**COMMENTS ON RESPONSES TO EXAMINING AUTHORITY'S
QUESTIONS 20/12/18**

**Application by
Highways England for an Order granting Development Consent for the A303
Sparkford to Ilchester Dualling**

**PINS Reference No: SPIL-SP0005 & 2001-4933
HBMCE Reference No: PL00285449**

**COMMENTS ON REVISED DRAFT DEVELOPMENT CONSENT ORDER
(SUBMITTED AT DEADLINE 2)**

C:\users\pas44049\dms44322\HE551507-MMSJV-LSI-000-DR-UU-2034.dwg Apr 26, 2019 - 9:00AM PAS44049

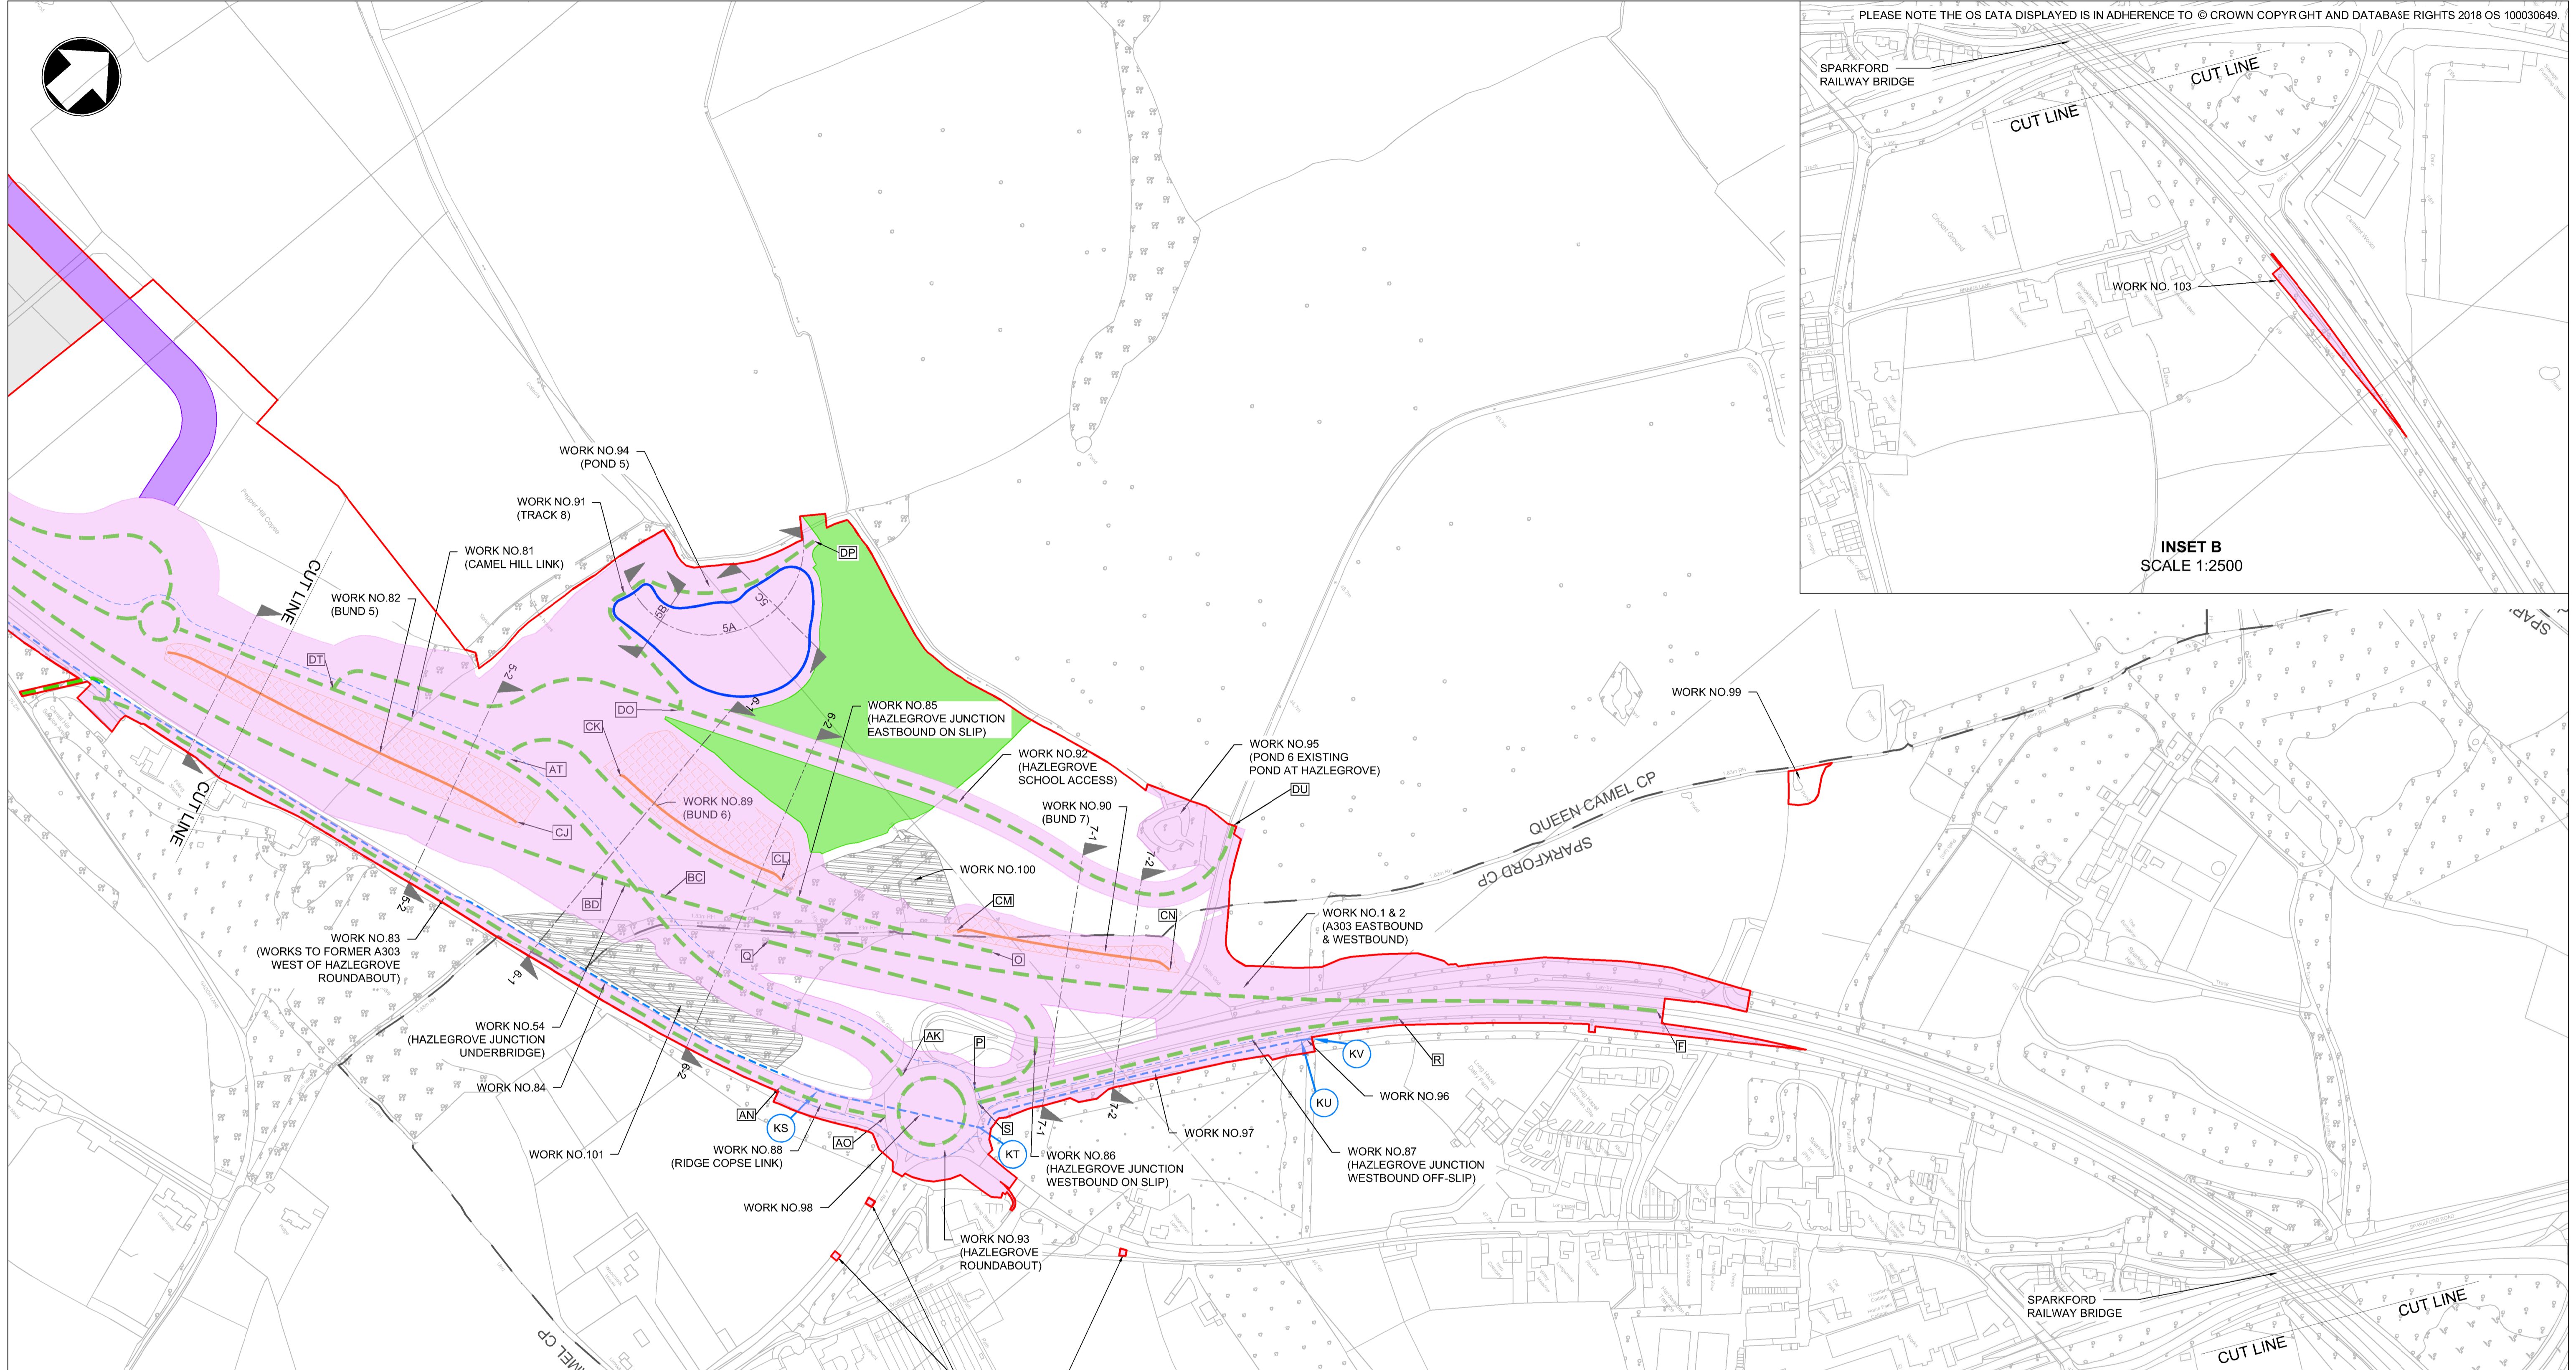
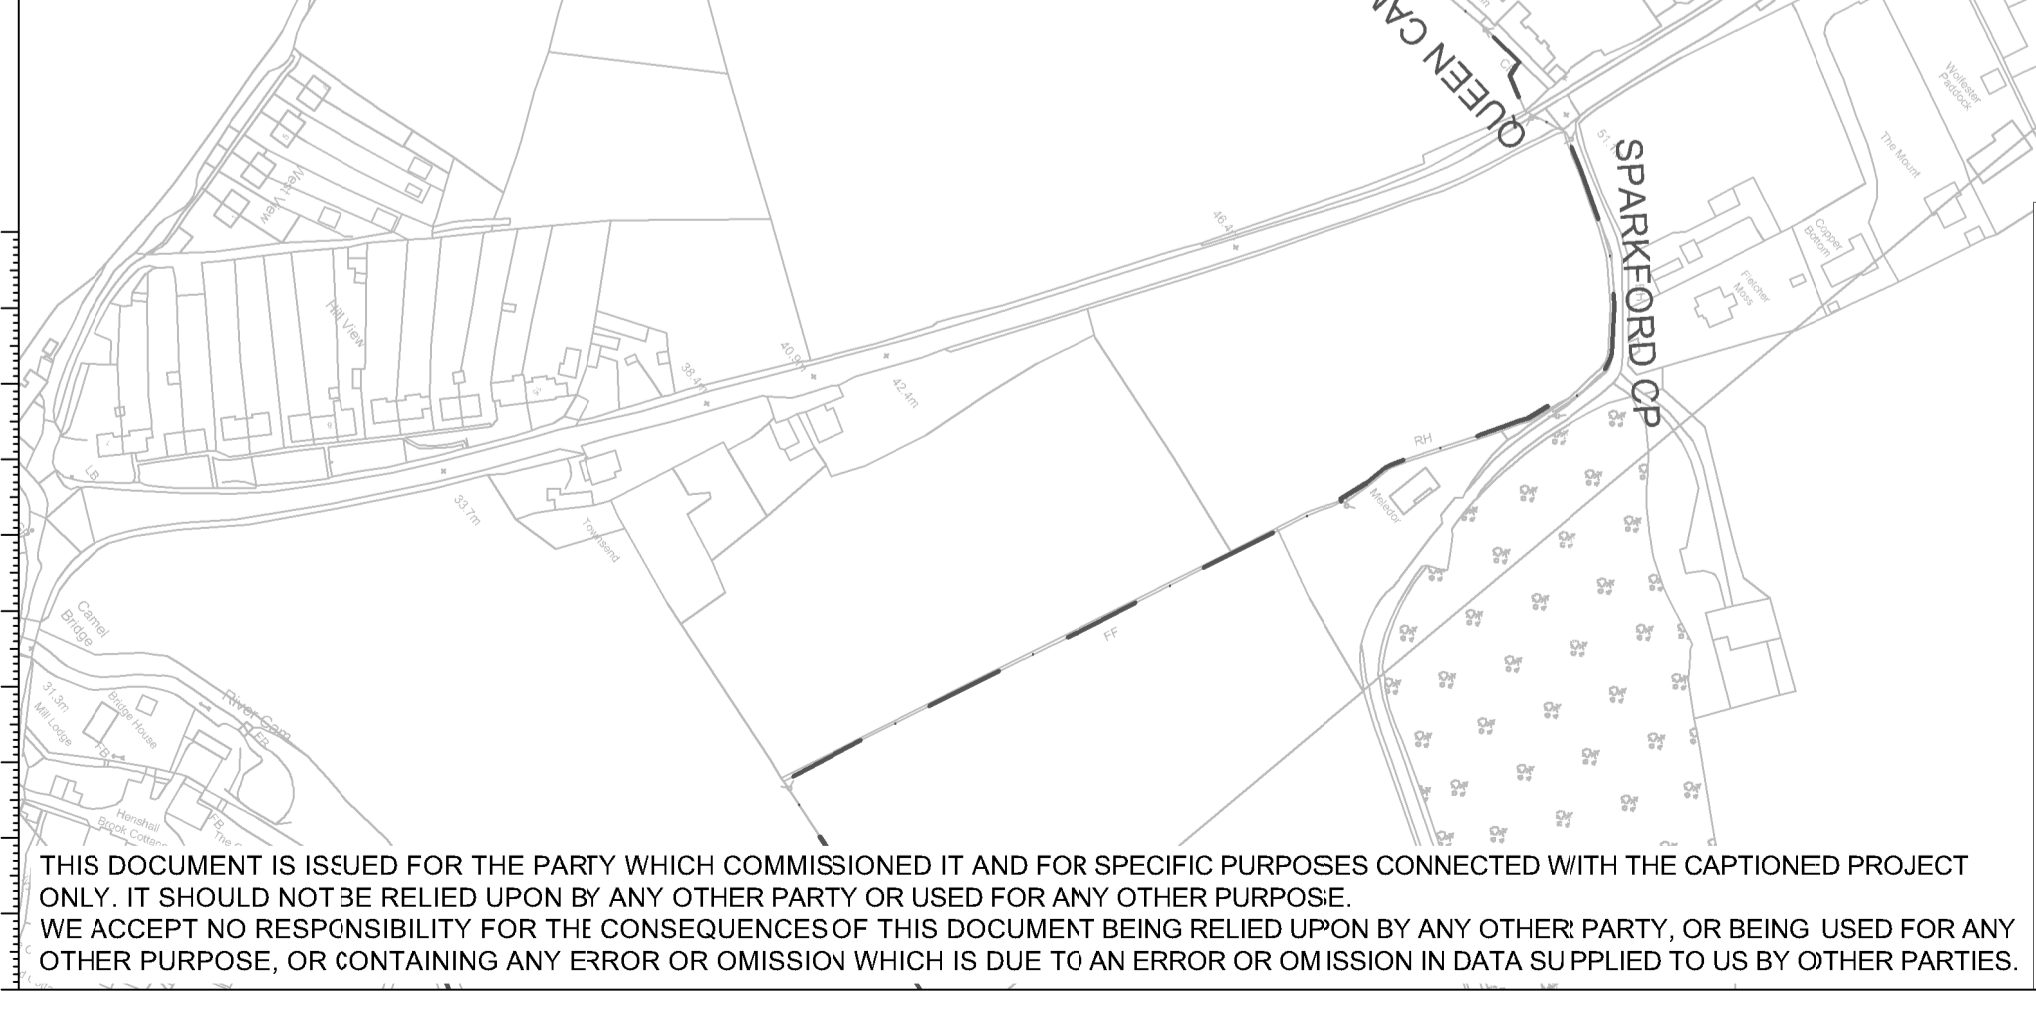
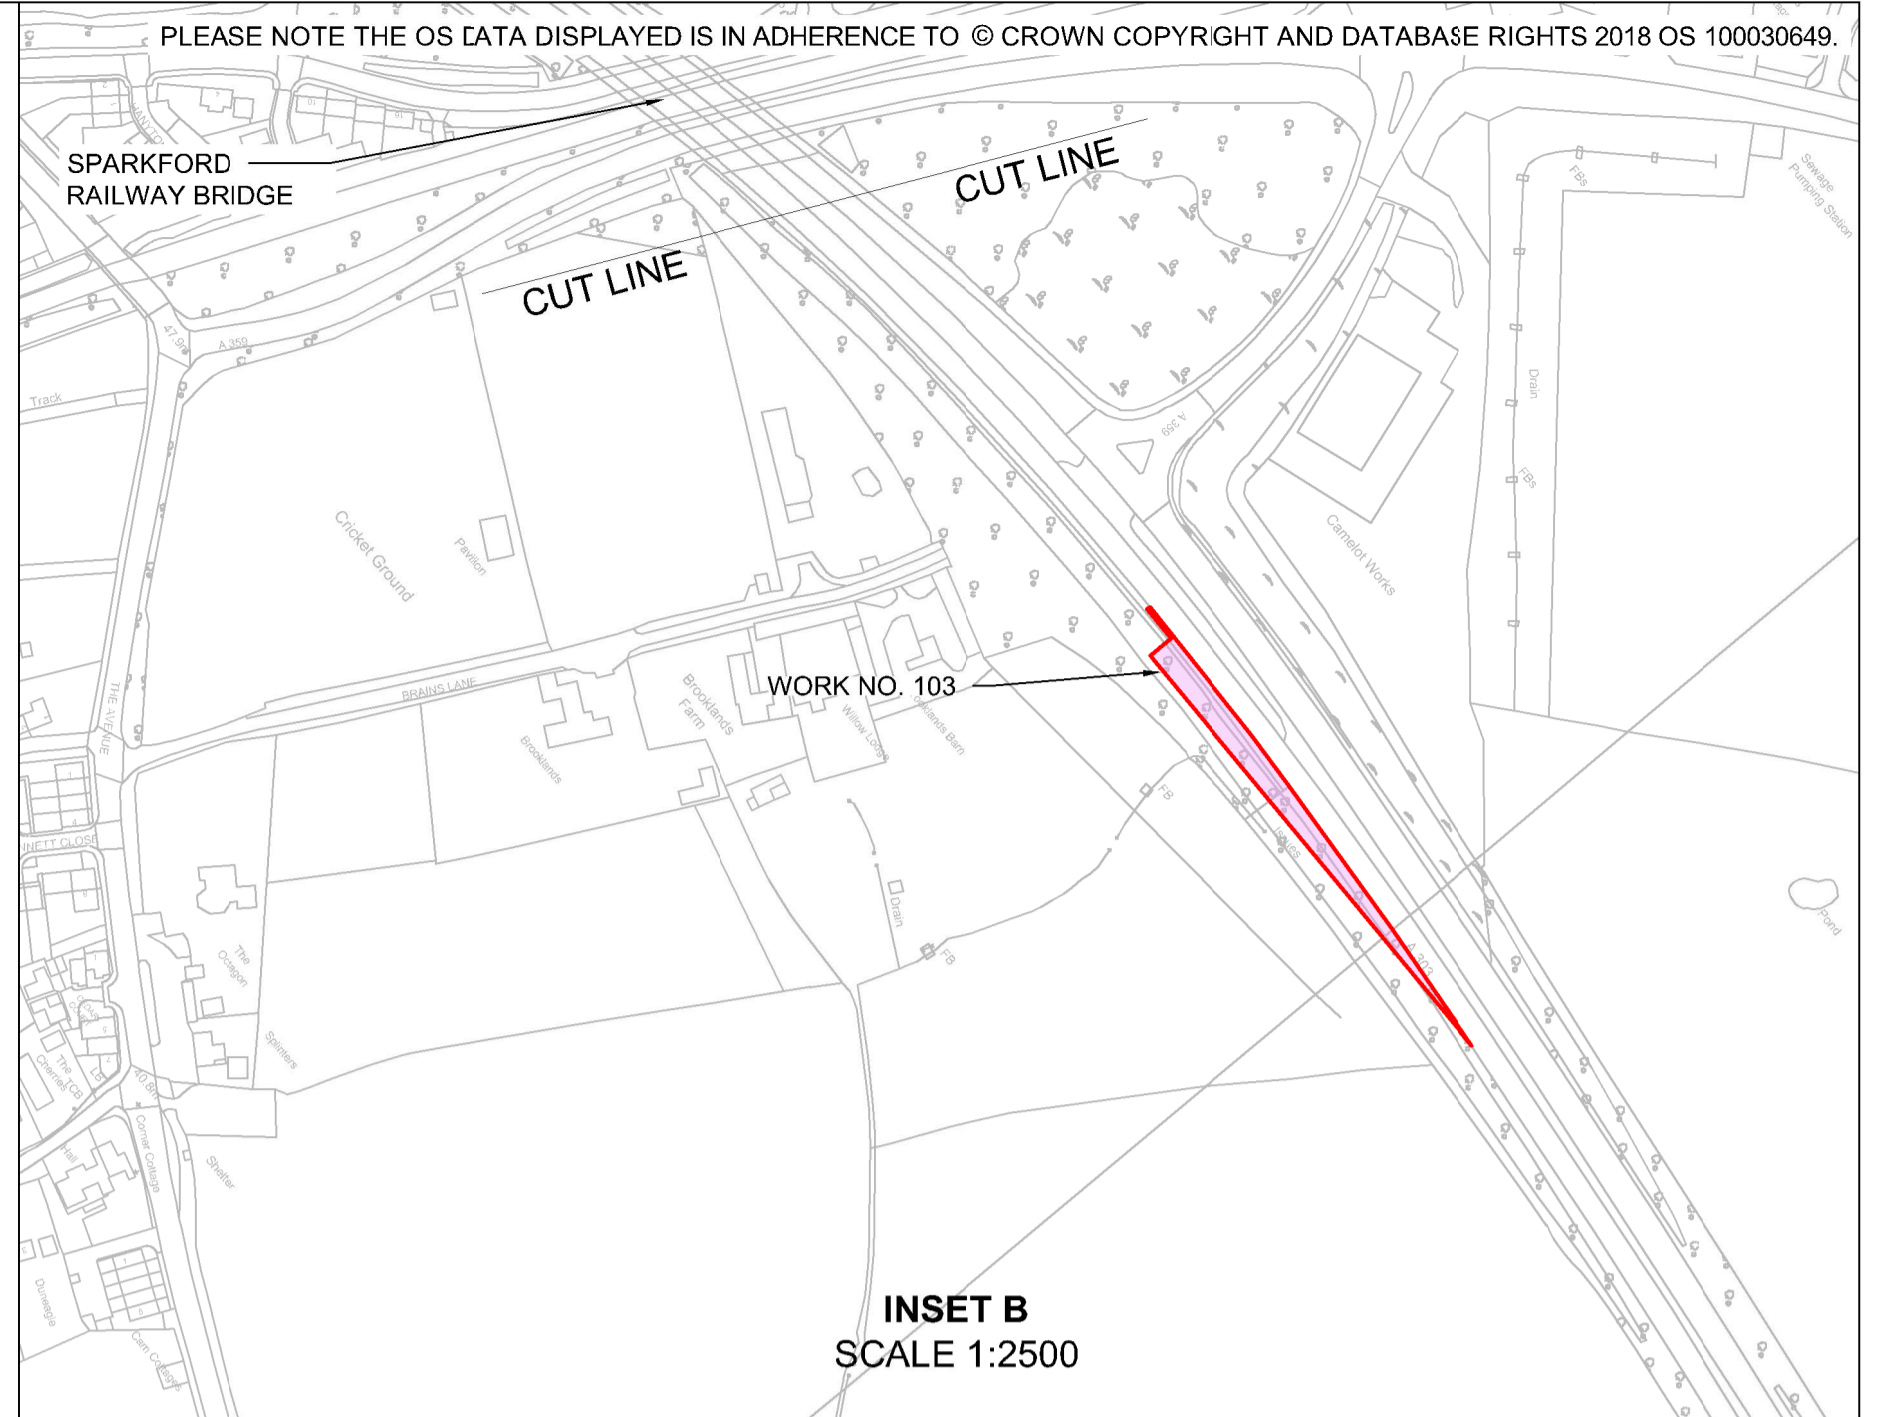
- 1.5. This was picked up as part of the Examining Authority's question – see question **1.10.9 (Article 2(1), a) Limits of deviation**). In our response to this question from the Examining Authority, we sought confirmation from the Applicant that the limit of lateral deviation included on the Works Plans (Sheet 3 of 4) would not entail encroachment within the Camel Hill Scheduled Monument. Whilst noting the response provided by Highways England, this remains a matter to be addressed and we will seek to discuss this further with Highways England.
